CITY OF ALBUQUERQUE

October 21, 2021

RE: **KABQ Cargo Facility**
3724 Spirit Dr. SE
Grading and Drainage Plan Stamp Date: 10/18/21
Drainage File: P15D004

Based on the submittal received on 10/20/21 the above-referenced Grading and Drainage Plan cannot be approved until the following are corrected:

VICINITY MAP  
IDO ZONE ATLAS NUMBER P-15

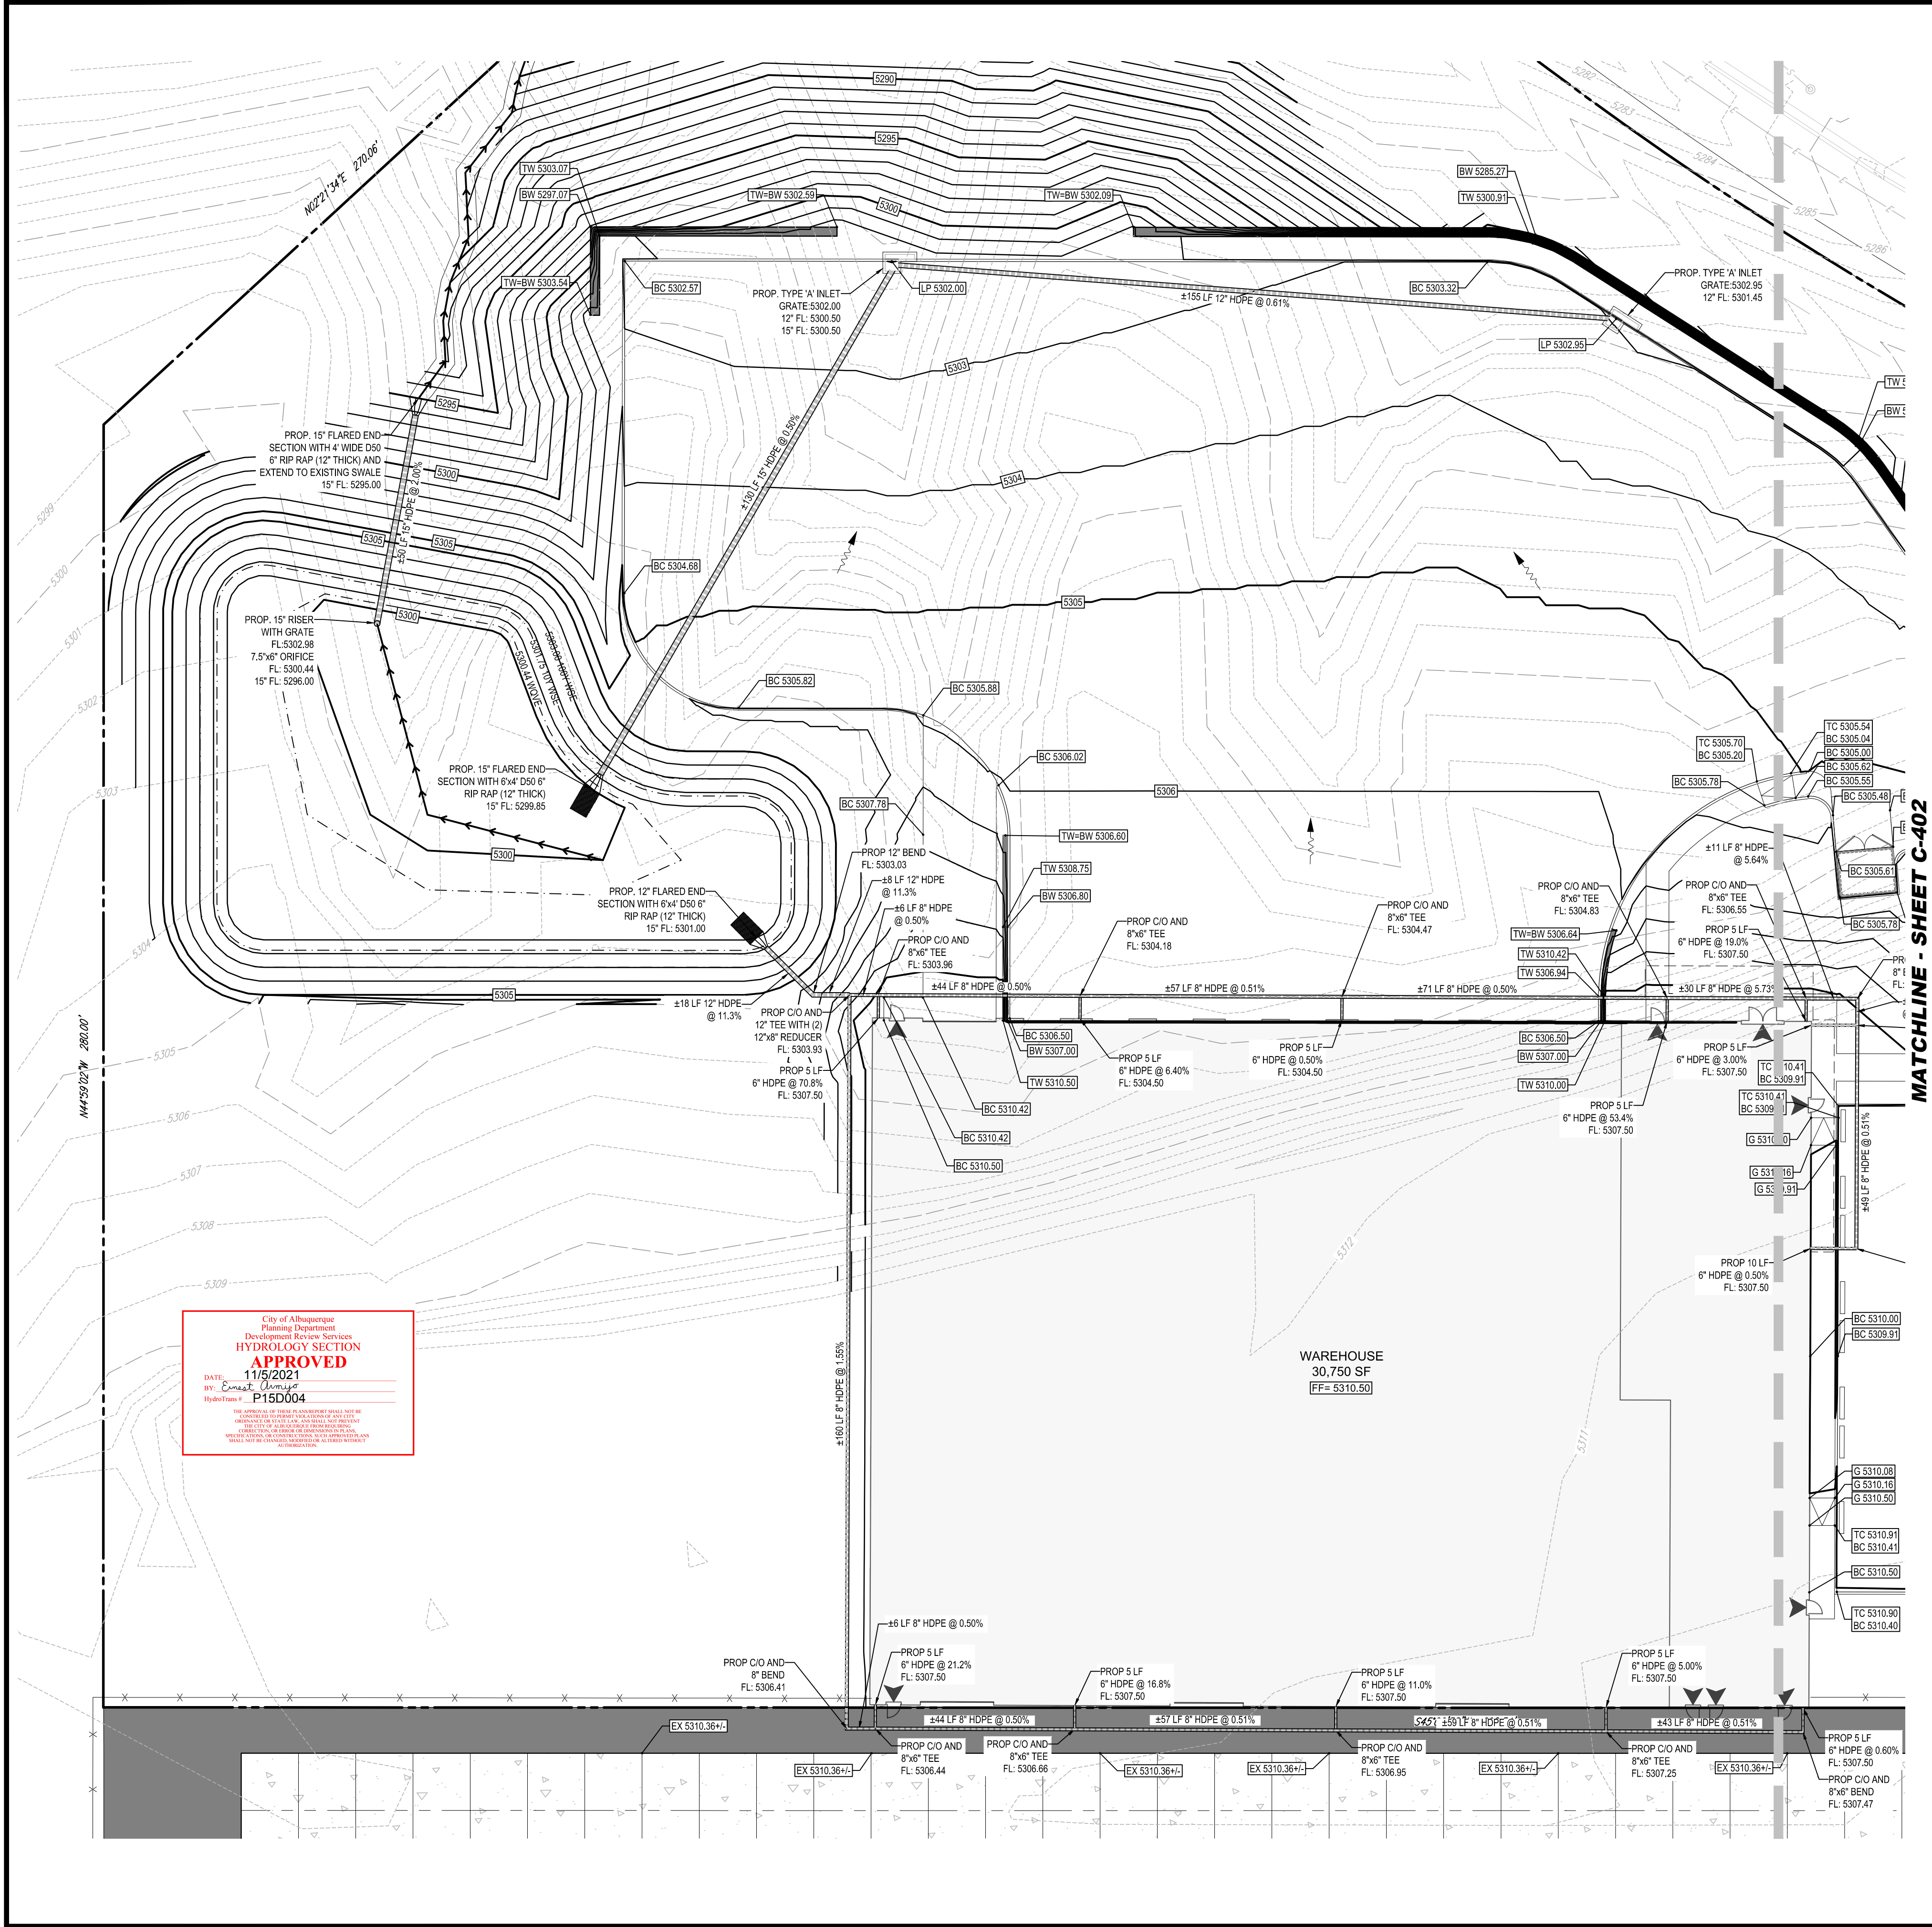
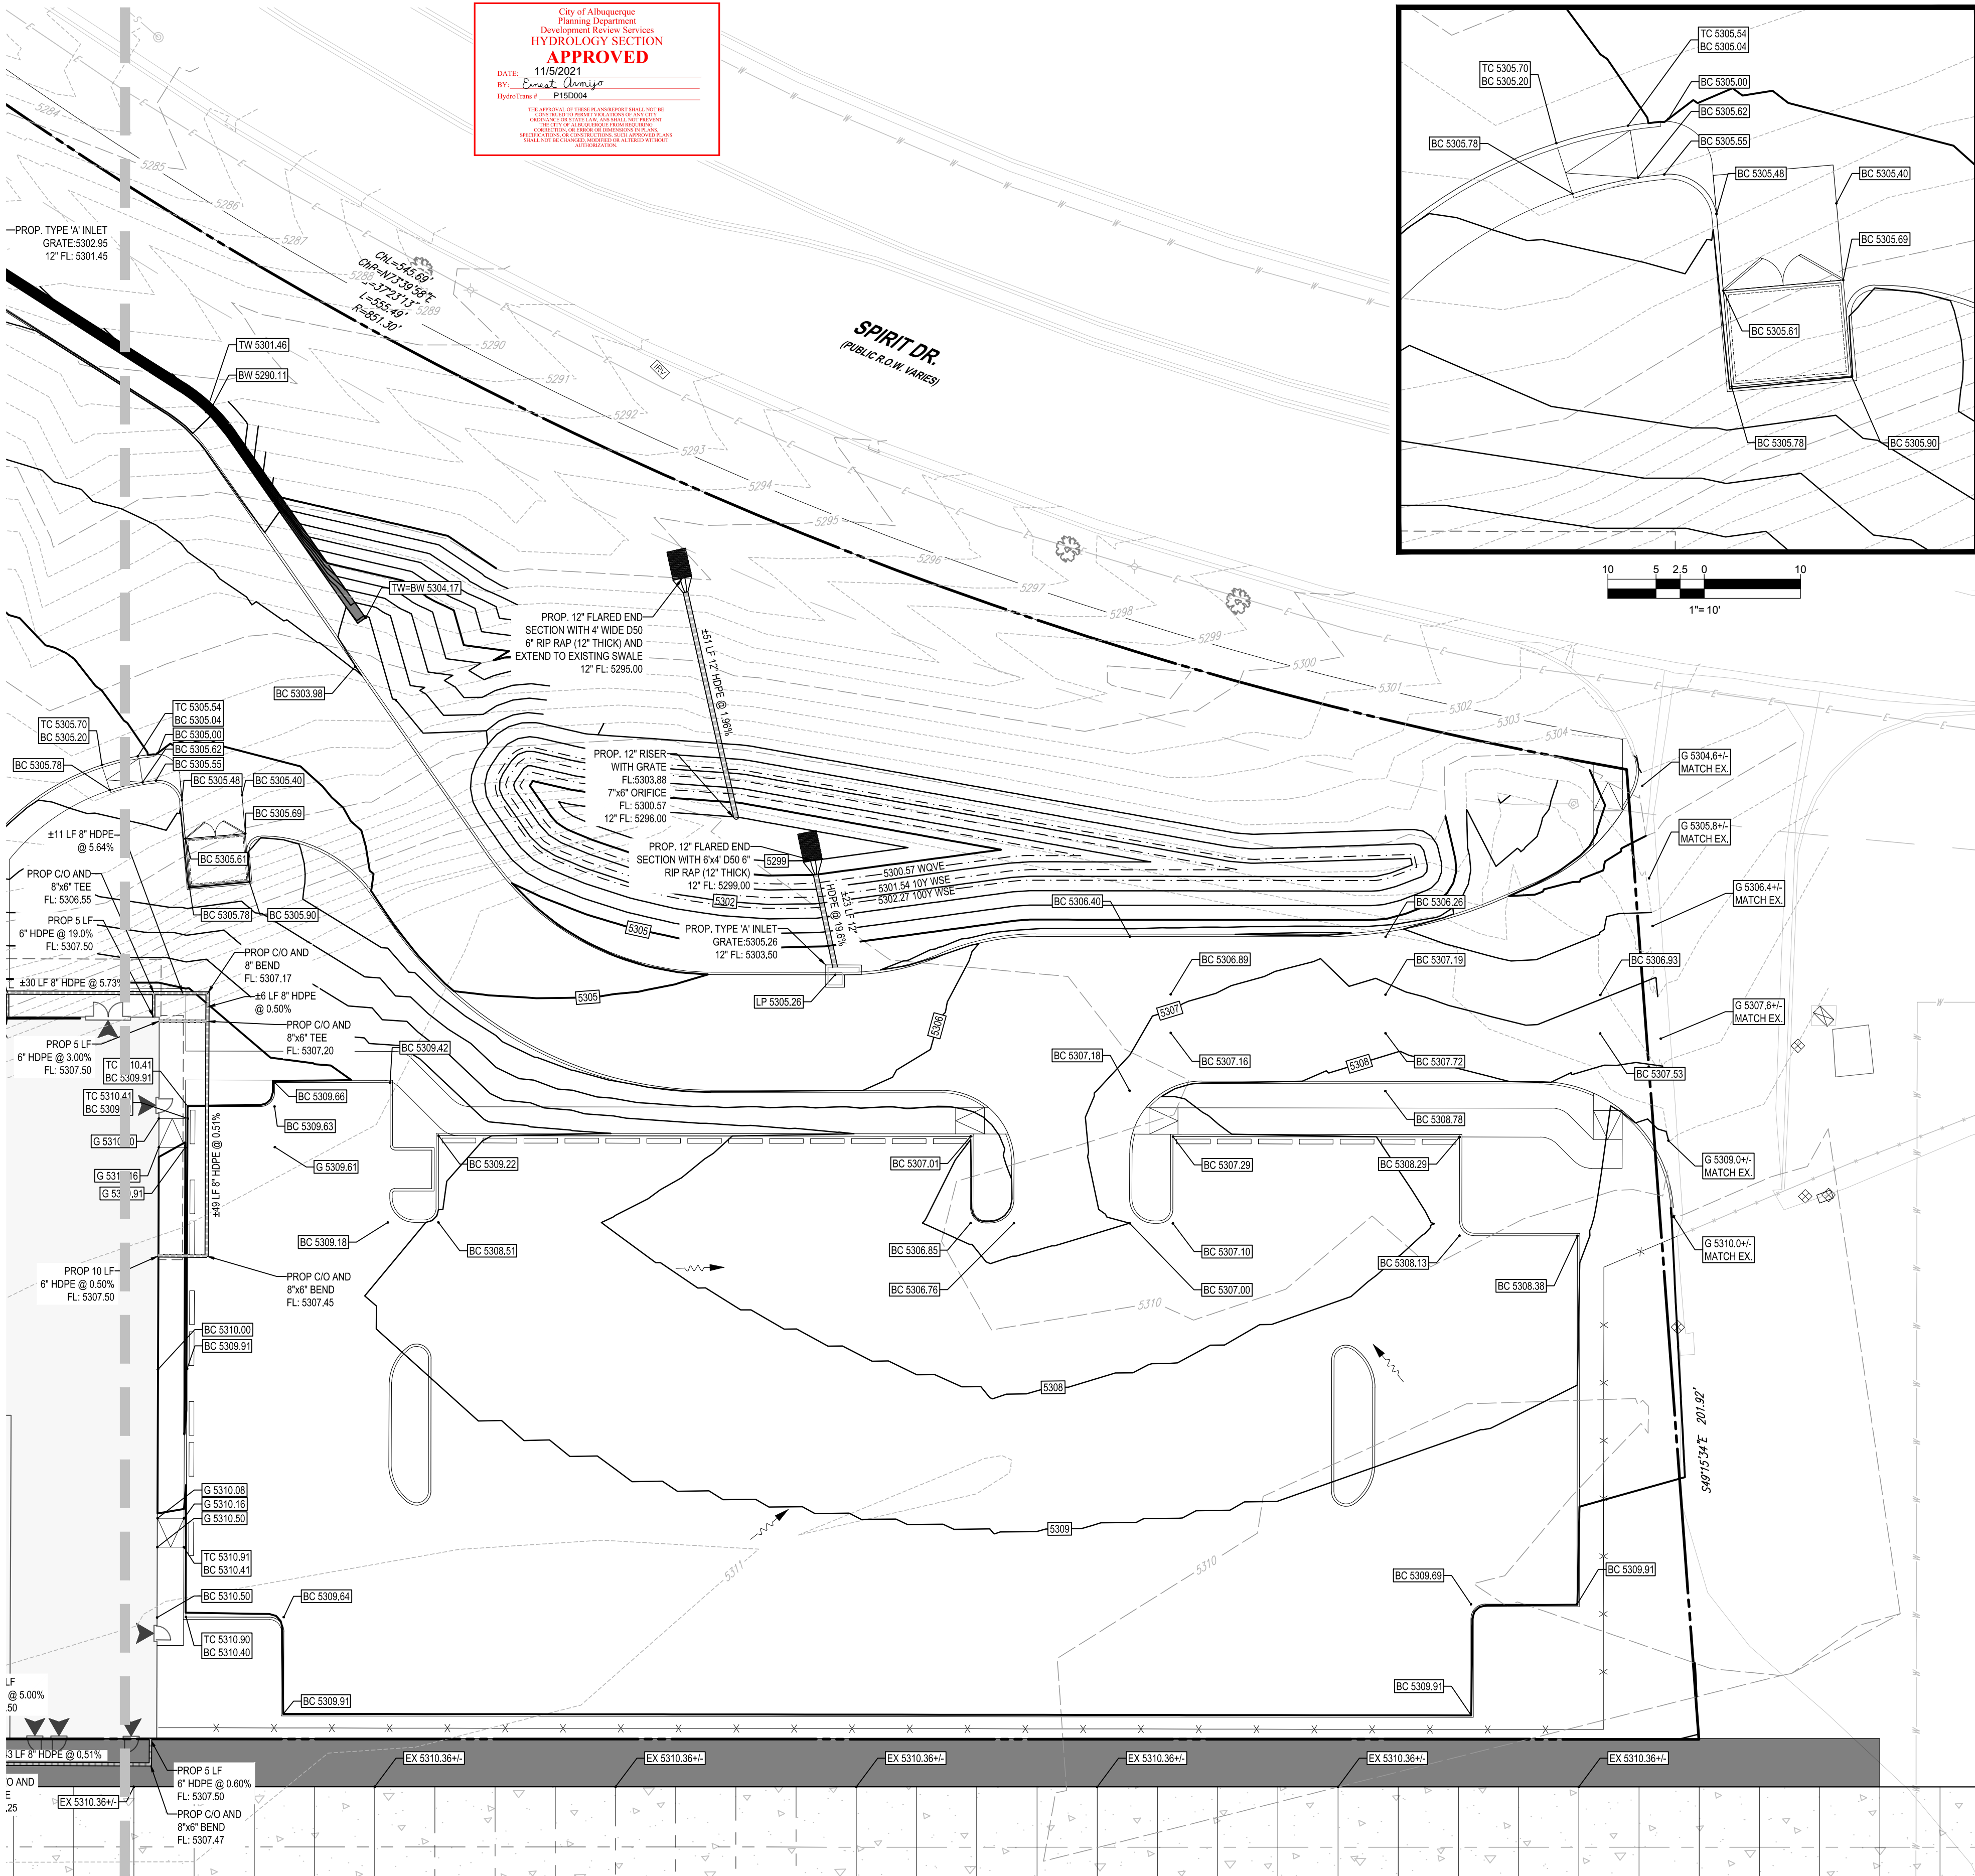
1. Per the DPM, the following must be on the Grading Plan (you have provided some of these items, but please ensure all the items are included).
 - a. Please provide an engineer's stamp with a signature and date.

- b. Please use 1" = 20' for the scale.
 - c. Please provide a Vicinity Map.
 - d. Please provide the Benchmark information (location, description and elevation) for the survey contour information provided.

- e. Please provide the FIRM Map and flood plain note with effective date.
 - f. Please provide a legal Description of the property.
2. Please provide a vicinity map showing the location of the site. Typically this is the Zone Atlas. This can be downloaded in pdf format from the City of Albuquerque's website. If you choose to use a vicinity map rather than the Zone map, please include the Zone Atlas number (P-15).

3. Please provide spot elevations along the boundary of the Cargo Apron (by others) to show how this ties in. Also indicate whether drainage flows are currently or will be crossing from this apron onto this site.

4. Please ensure that the survey that the Grading Plan is based on is a recent survey and not contours from older airport projects, as older survey information may no longer be accurate.

7. The site must demonstrate adequate downstream capacity per § 14-5-2-12(G) of the Albuquerque Code of Ordinances. Based on a review of the ABQ Master Drainage Plan (M16D024-see attached excerpts) this site has an allowable discharge rate of 0.48 cfs/acre for the 100 year-6 hour storm. What you have designed is in excess of this which will require more detention on-site.

8. Please use the procedure for 40 acre and smaller basins as outlined in Development Process Manual (DPM) Article 6-2(a). Please provide both the existing conditions and proposed conditions for the 100 year-6 hour storm event. I did not see calculations for the existing conditions.

9. Please show and number drainage basins and show how drainage basins flow to ponds or outfalls. Calculate runoff for basins individually. Looking at the Grading Plan it appears as if the loading dock area in front of the warehouse is draining directly to an opening between retaining walls, down a slope directly to Spirit Drive without reaching the ponds. All flows must account for Storm Water Quality Volume (see comment 13).

10. Please add a note to the plans stating "Stabilize all pond slopes with native seed and aggregate mulch or equal (must meet CGP 2.2.14b).
11. On your pond sections also show two foot of freeboard (not one), the 100 year-6 hour water surface elevation (WSE), Storm Water Quality Volume WSE, spillway (at the 100 year-6

- hour WSE) and a riser in the pond (if you choose to use one rather than the manhole with weir plates you currently have as it may be a cheaper solution for you).
12. Please use the following parameters in HEC_HMS per the City DPM to analyze routing for the ponds and their outlets and include the model in your resubmittal.
- The use of just four Curve Number (CN) values, one for each of the land treatments already described in the DPM: A=76, B=80, C=85 and D=98. This way the hydrologic soil groups don't need to be determined to select the CN and the soil maps do not need to be consulted.
 - These CNs are for a 24 hour precipitation distribution using NOAA Atlas 14 with the peak at 6 hours.
 - $Lag=0.6T_c$ where T_c is calculated using the procedure already in the DPM

13. Provide management onsite for the Stormwater Quality Volume (SWQV) in accordance with the new drainage ordinance, § 14-5-2-6 (H) enacted 10/2/18 (Council Bill C/S O-18-2). Please show the top and bottom of the ponds along with the volume for each pond. The onsite drainage should be directed to these ponds prior to being collected in a private unground drainage system or allowed to outlet. Please follow the DPM (signed 06/08/20) Article 6-12 Stormwater Quality and Low-Impact Development for the sizing calculations. To calculate the required SWQV, multiply the impervious area draining to the BMP by 0.42 inches for new development sites. The calculations of both the required and the provided volume of each BMP must be shown on the Grading and Drainage Plan. Each BMP should be labeled on the Grading and Drainage Plan with the required SWQV and associated water surface elevation and the 100-year water surface elevation. Landscaping of surface BMPs is also required to be noted on the Grading and Drainage Plan.

14. Please number the ponds and include a label on each with the SWQV and elevation, the 100-year volume and elevation, the peak 100 year inflow and outflow, the spillway crest elevation, the spillway flow depth, and the dam top elevation. The invert of the outlet pipe for each pond must be above the elevation of the SWQV.

15. Please provide the SWQV calculations for each basin draining to each pond. The stormwater quality ponds need to be sized for the areas draining to them.
